Odour Assessment Review
Land at Ford Airfield, Ford,
West Sussex
November 2021

Project no.	Project
8693C	Odour Assessment Review: Land at Ford Airfield, Ford, West Sussex

Client	
Arun District Council (ADC)

Report No.	Version	Prepared by	Checked by	Authorised by	Date of issue
11050	V0	H. Parfitt	P. Beckett	P. Beckett	19/11/2021

Crown copyright and database rights 2021  
Ordnance Survey 0100031673  
OS data licence expiration: 05.02.22

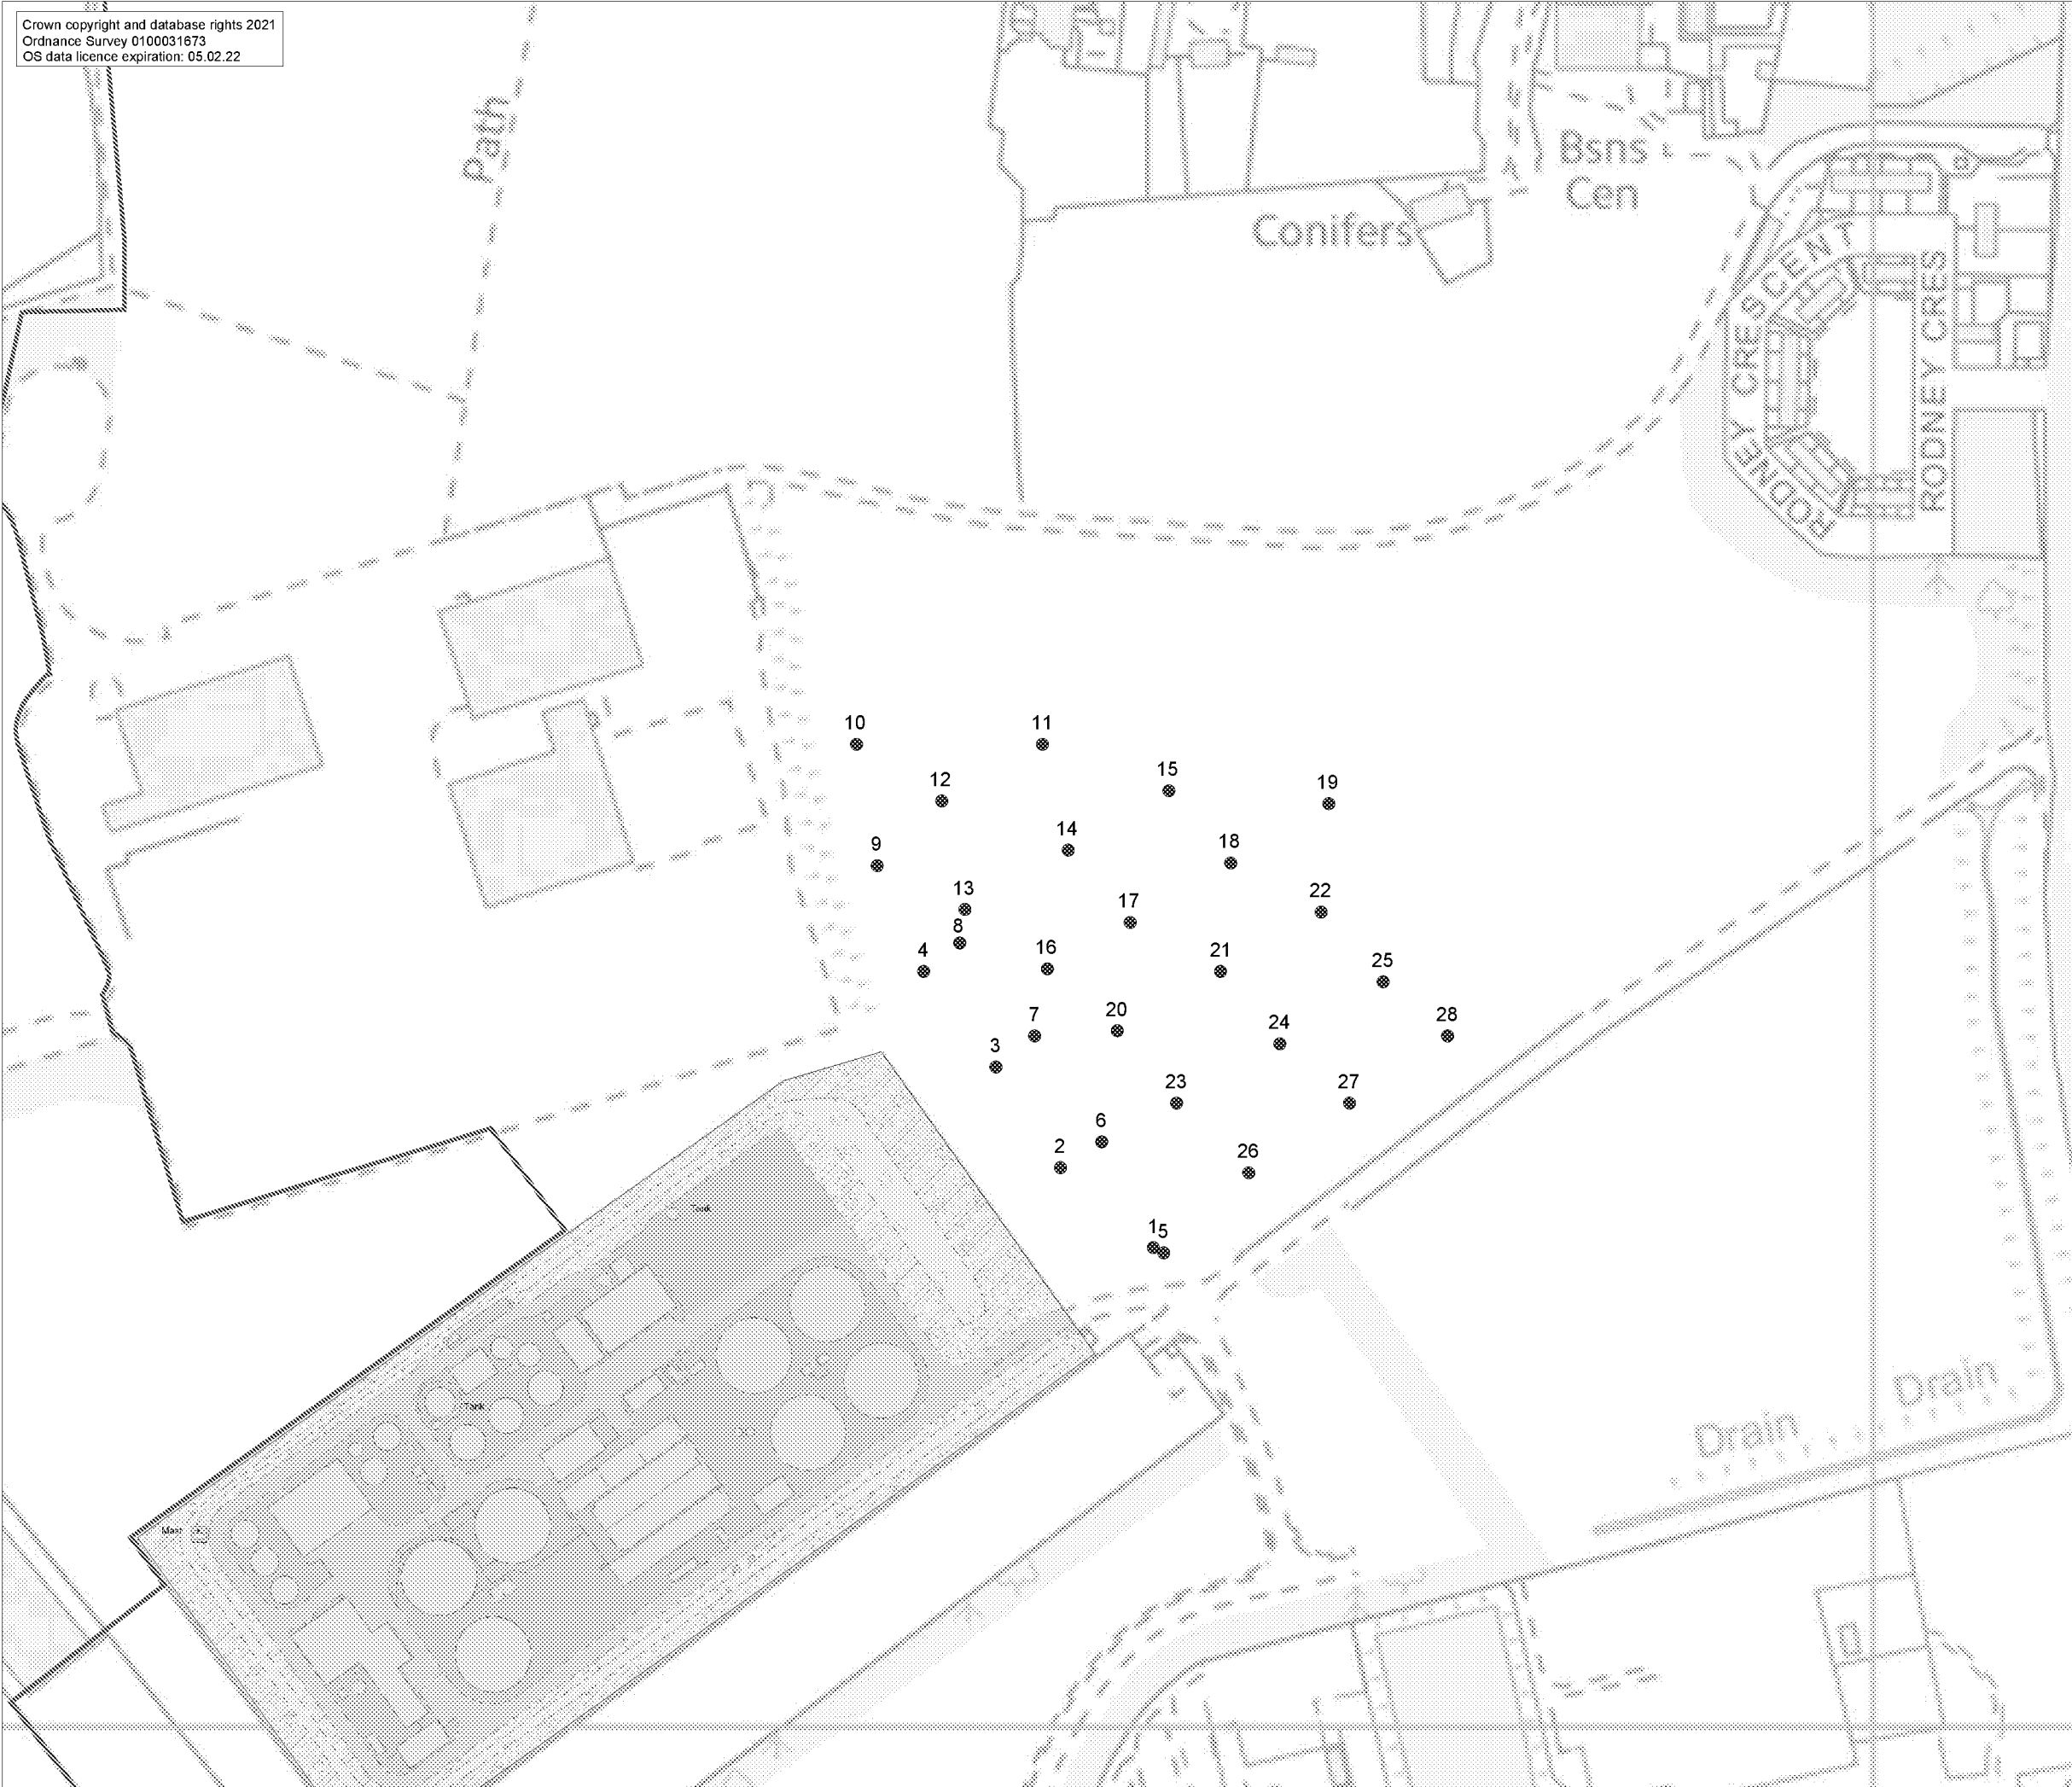
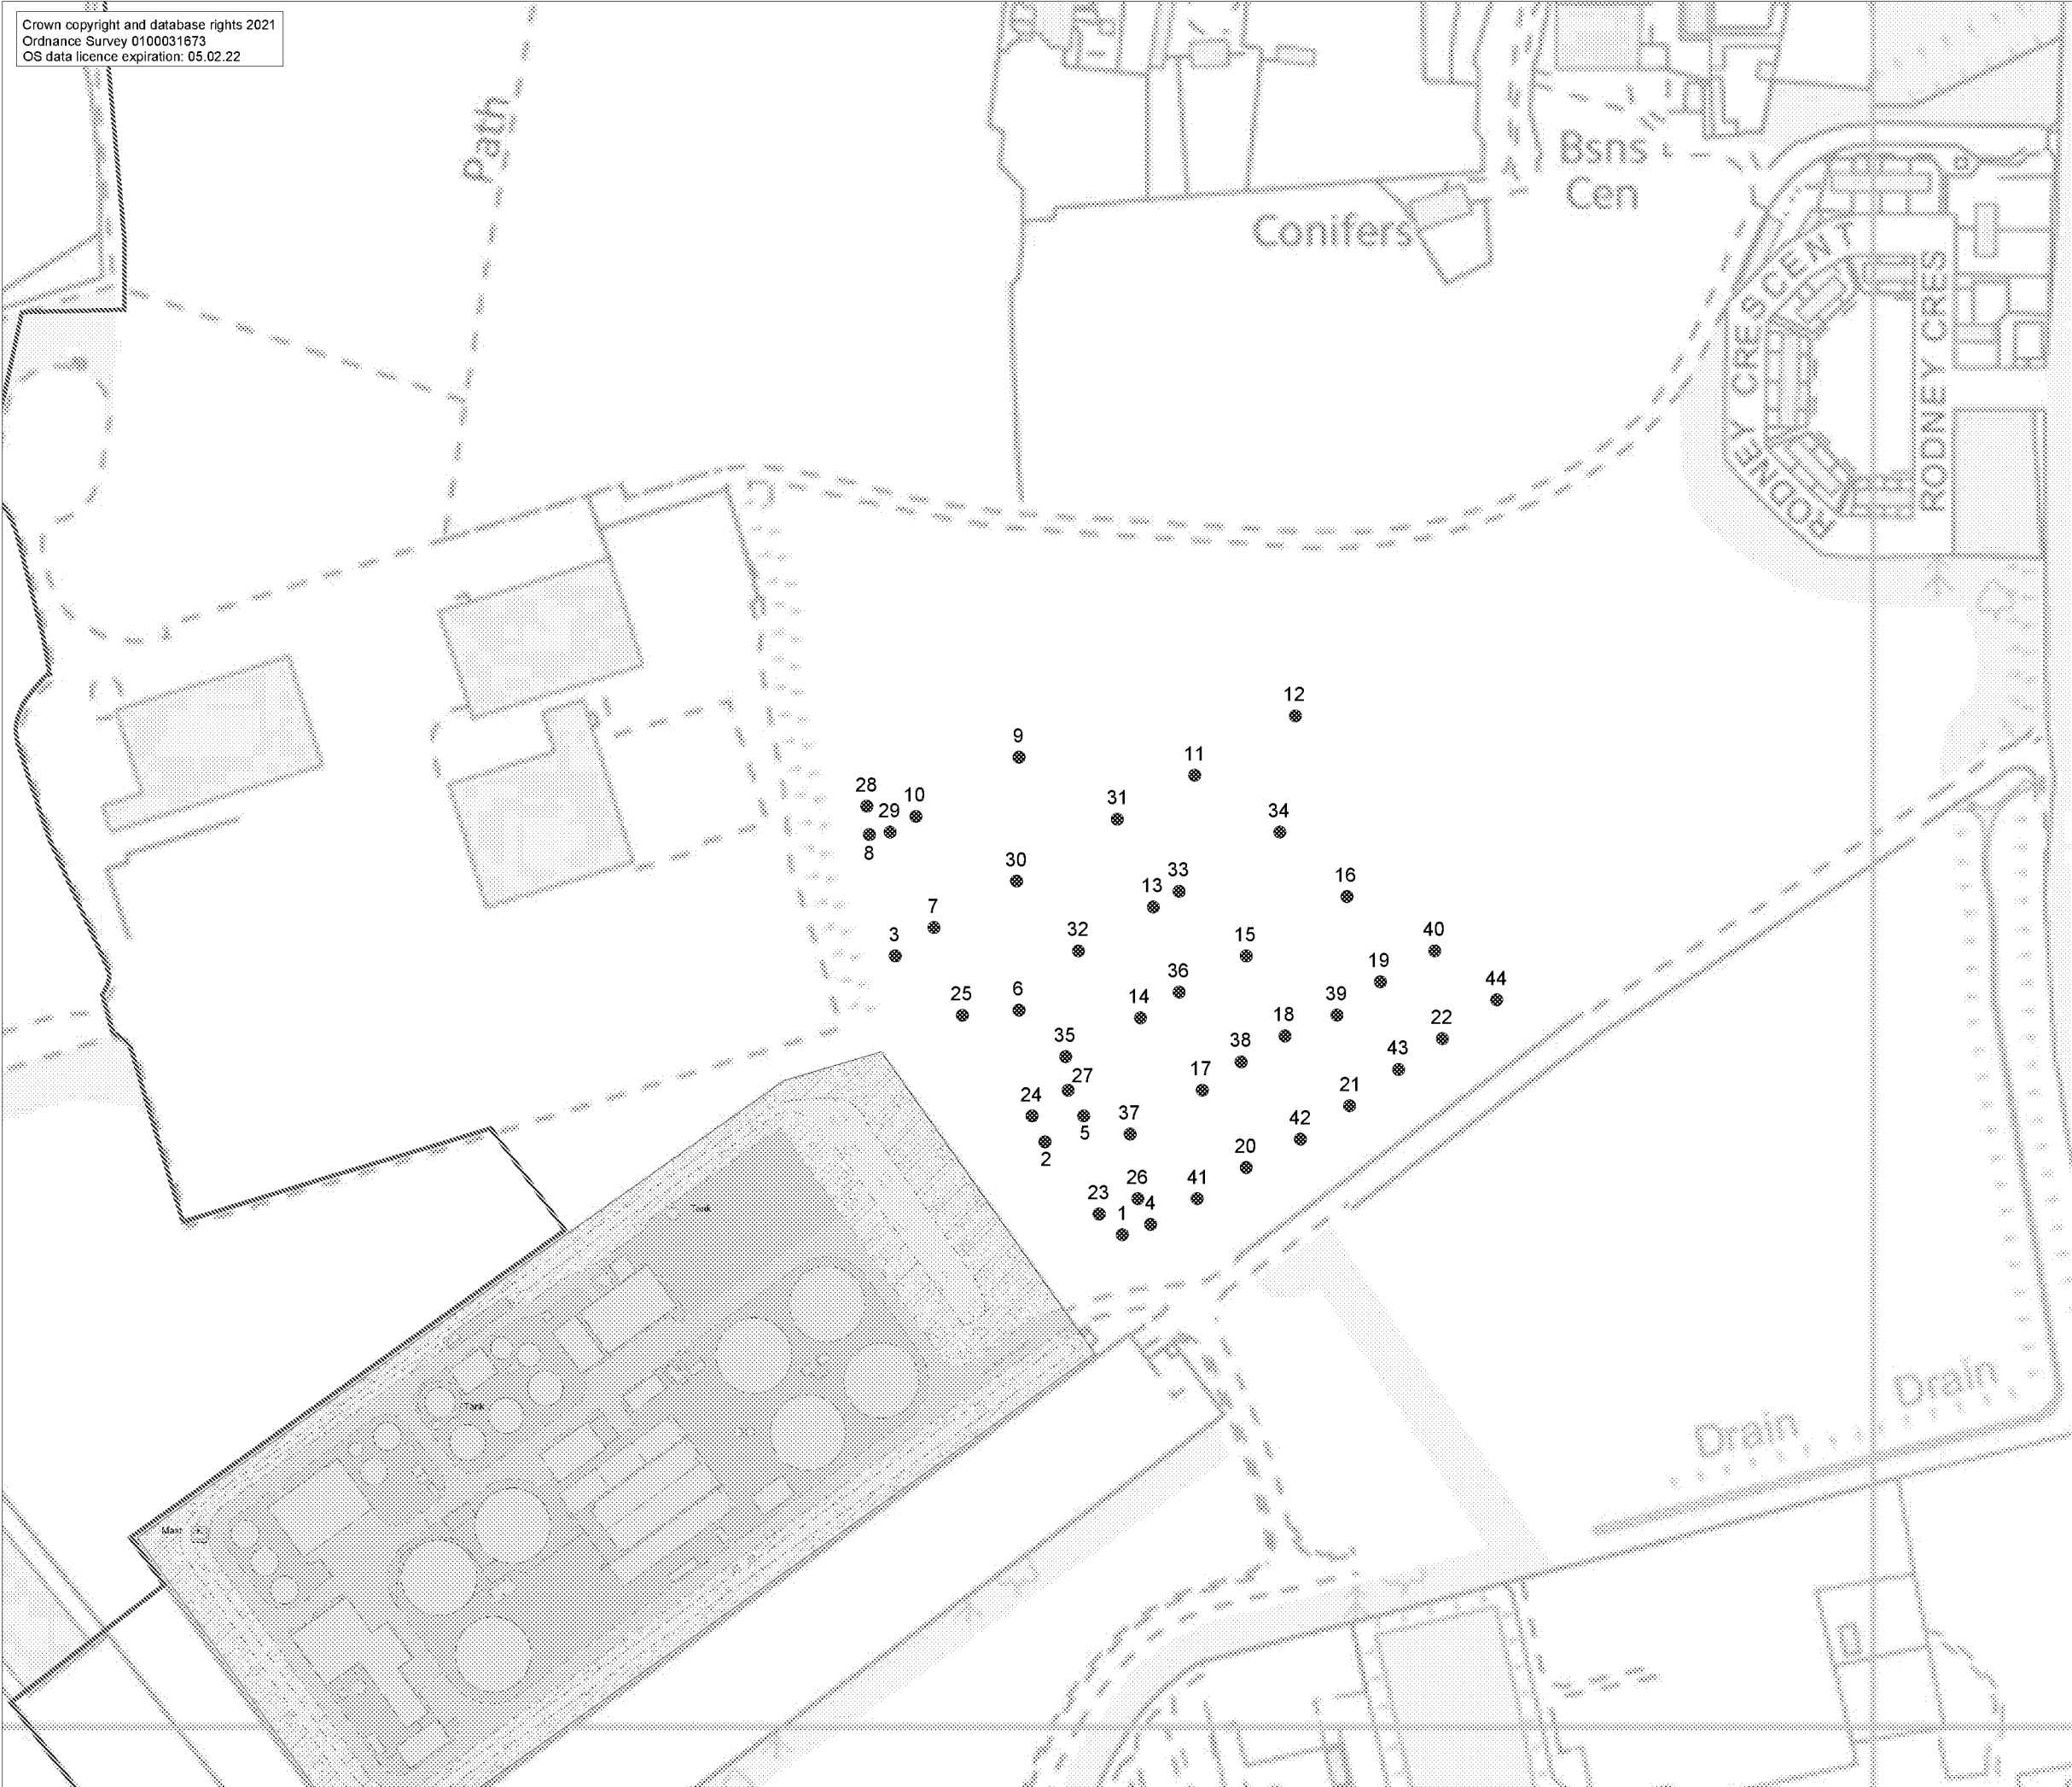
- 2.30 During walkover/sniff test 1, strong odours could be detected transiently but regularly up to 120m from the WwTW boundary, and at least 300m from the most odorous part of the WwTW, i.e., the main works odour control unit. The three locations where strong odours could be detected were not the three closest, as is suggested in the report, suggesting that a plume from the OCU might be grounding there.

- 2.31 Nevertheless, there is consistency in the results of the sniff tests (i.e., that the area within 100m of the WwTW to the NW is regularly exposed to strong odours that could be *"regarded as 'substantial adverse' for a residential receptor and 'moderate adverse' at a commercial receptor"*. This area is at least 300m from the most odorous part of the WwTW, i.e., the main works OCU.

- 2.32 During sniff test 3, strong odours could regularly be detected along the WwTW southern boundary (locations 5 to 14); however, strong odours quickly dissipated when sampling at locations 22-29, which were circa 70m to the south. The sniff test did not sample at greater distances to the south. It is, therefore, unknown whether odours could be detected at 300m distance from the main OCU, as they could be to the north-east of the WwTW. This is a possibility given the height and design of the OCUs, which would allow odorous air to ground at greater distances from the facility.

- 2.40 For example, the sniff tests find that moderate & substantial adverse impacts (assuming residential uses were present) could be consistently detected to the north-west of the WwTW up to 100m from the site boundary, and over 300m from the most odorous part of the WwTW. However, the modelling suggests impacts would be, at worst, 'slight adverse' at this location. This suggests that impacts associated with normal operations of the WwTW could be under-predicted to the north-west of the facility and that the model is not performing in line with the prevailing meteorological conditions and with the ground based observations.
